About the application

Application number: 2025/91840	
What is the application for?:	Alterations to stable to create dwelling forming annex accommodation associated
Address of the site or building:	Northorpe Barn, 32A, Northorpe Lane, Mirfield, WF14 0QN
Postcode:	WF14 0QN

Type of comment: An objection	
Do you wish your comments to be published on the website anonymously?	Yes

Title
Proposed Floor Plan and Elevations

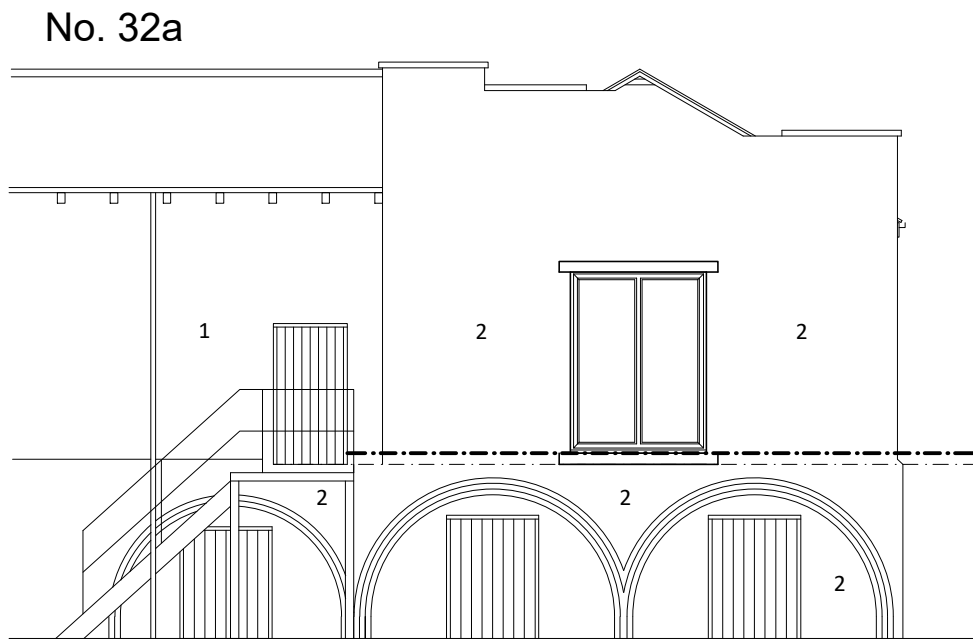
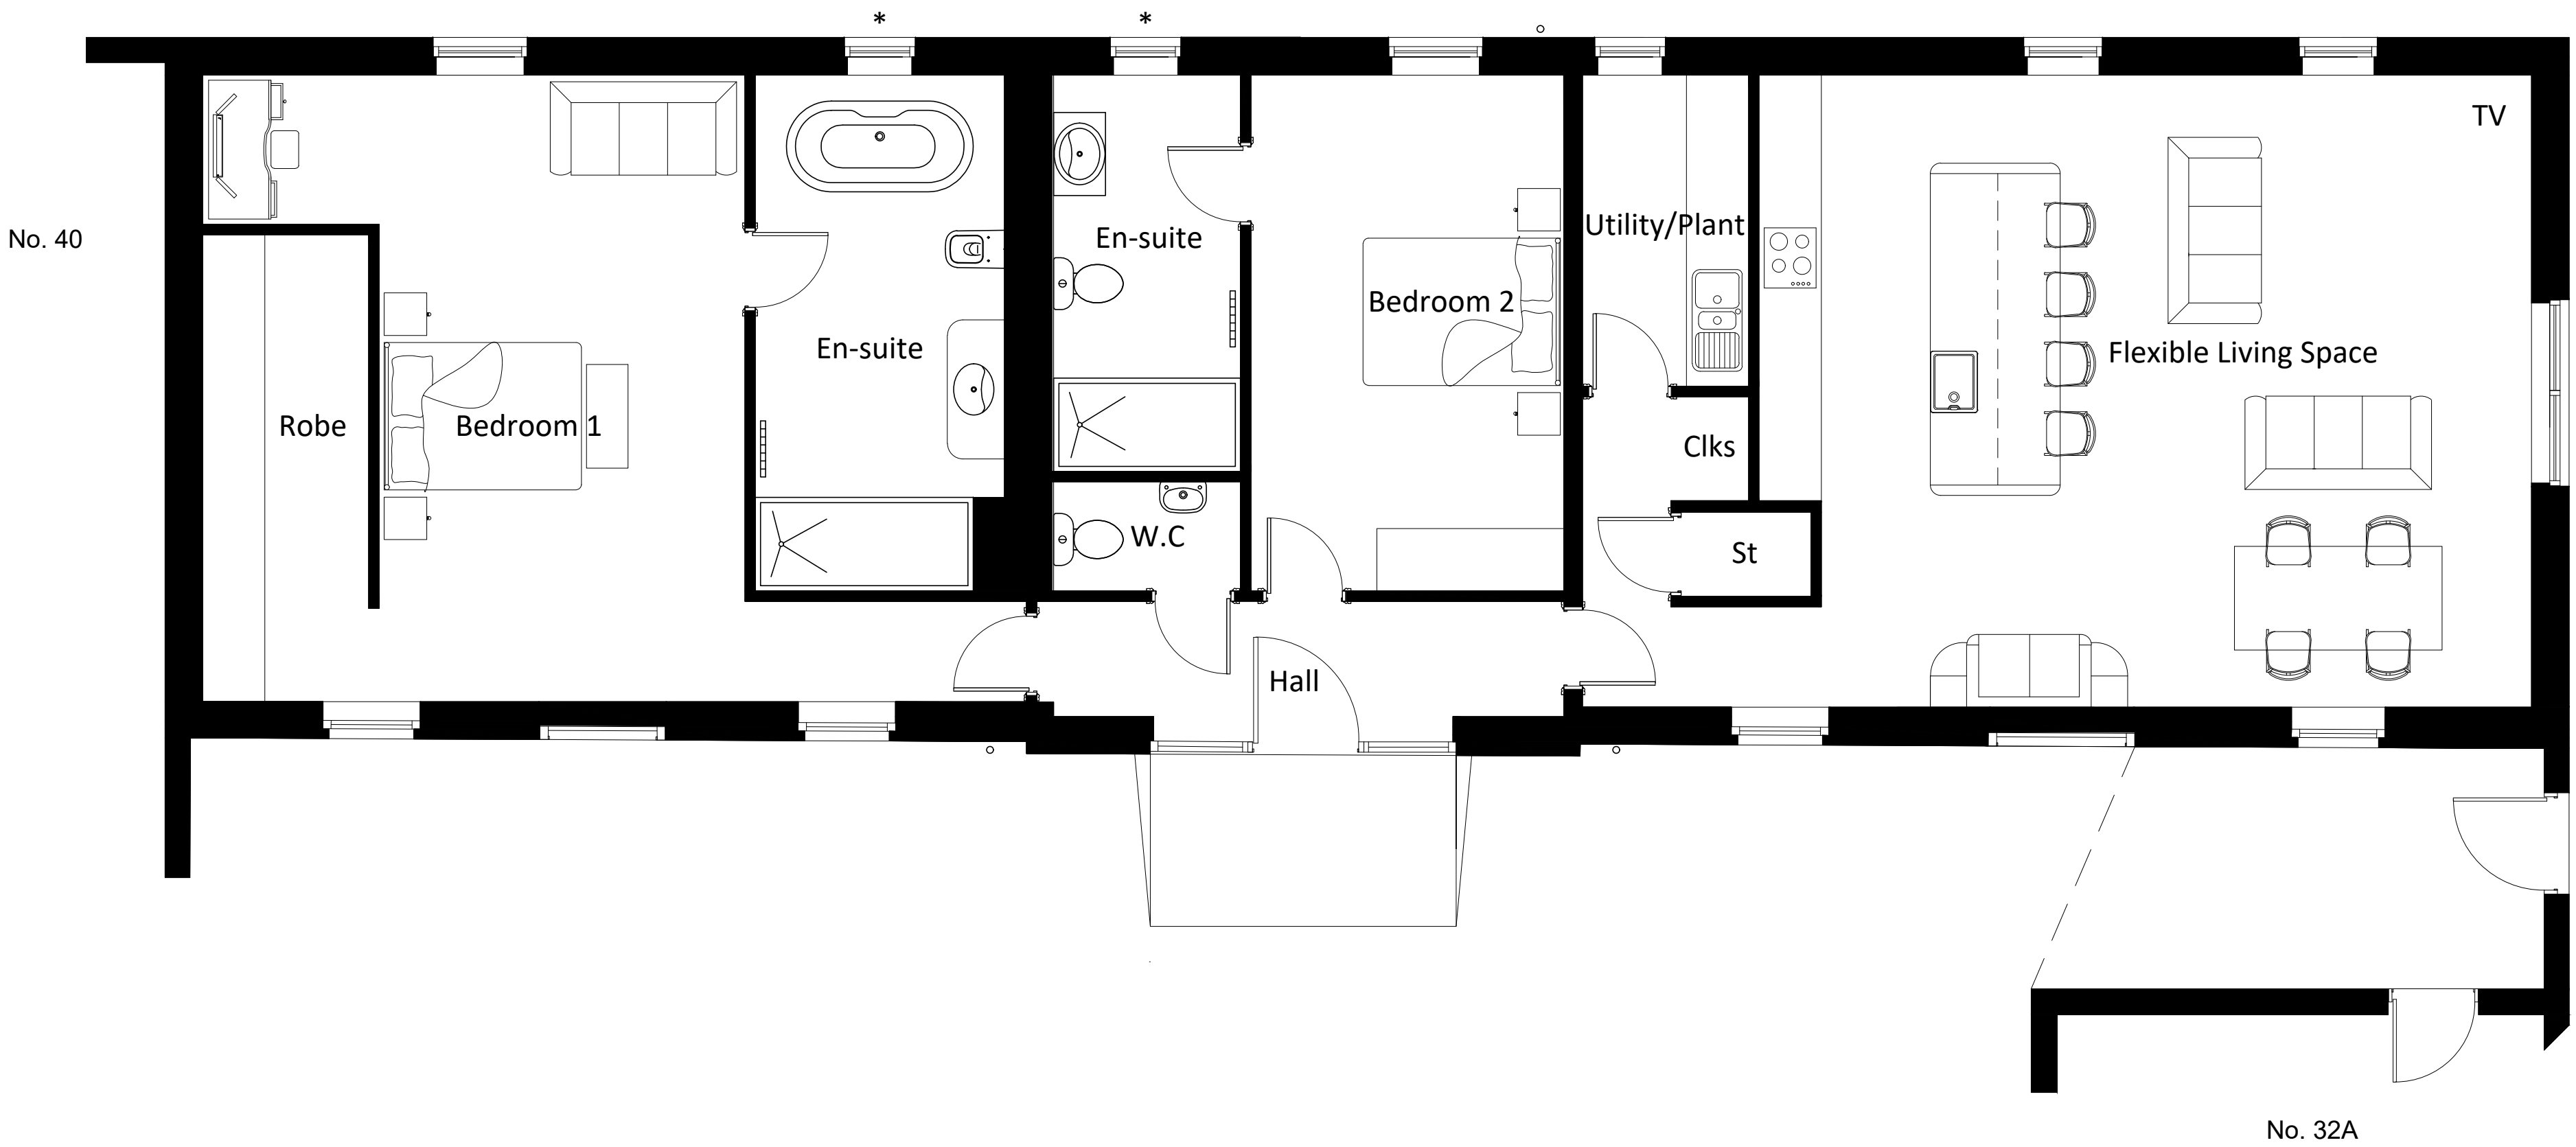
On reviewing the plans submitted, we note that the proposed annexe is similar in size to the current dwelling and does not appear to be subordinate to the main bungalow. The scale of the proposed conversion exceeds what would be considered as ancillary accommodation and whilst it may not be considered to dominate the site, it is certainly of very similar proportions to the existing dwelling, to the extent of being considered a second dwelling. Our concern is that if planning consent is granted for the "annexe" in its current form there will ultimately be a future application to separate this new accommodation from the existing dwelling and create two standalone units. For this reason we consider that the design should be scaled back to ensure a clear distinction between the main dwelling and the annexe in terms of both size and function.

We appreciate that for family reasons Ms Ingham may wish to create separate accommodation for her parents, but as noted, the scale of the proposed conversion does not constitute a subordinate or ancillary space and this gives rise to justifiable concerns as to the long term prospects for the future use of building. In our opinion a reduction in scale of the proposed accommodation is required to maintain the necessary distinction between the main dwelling and the annexe.
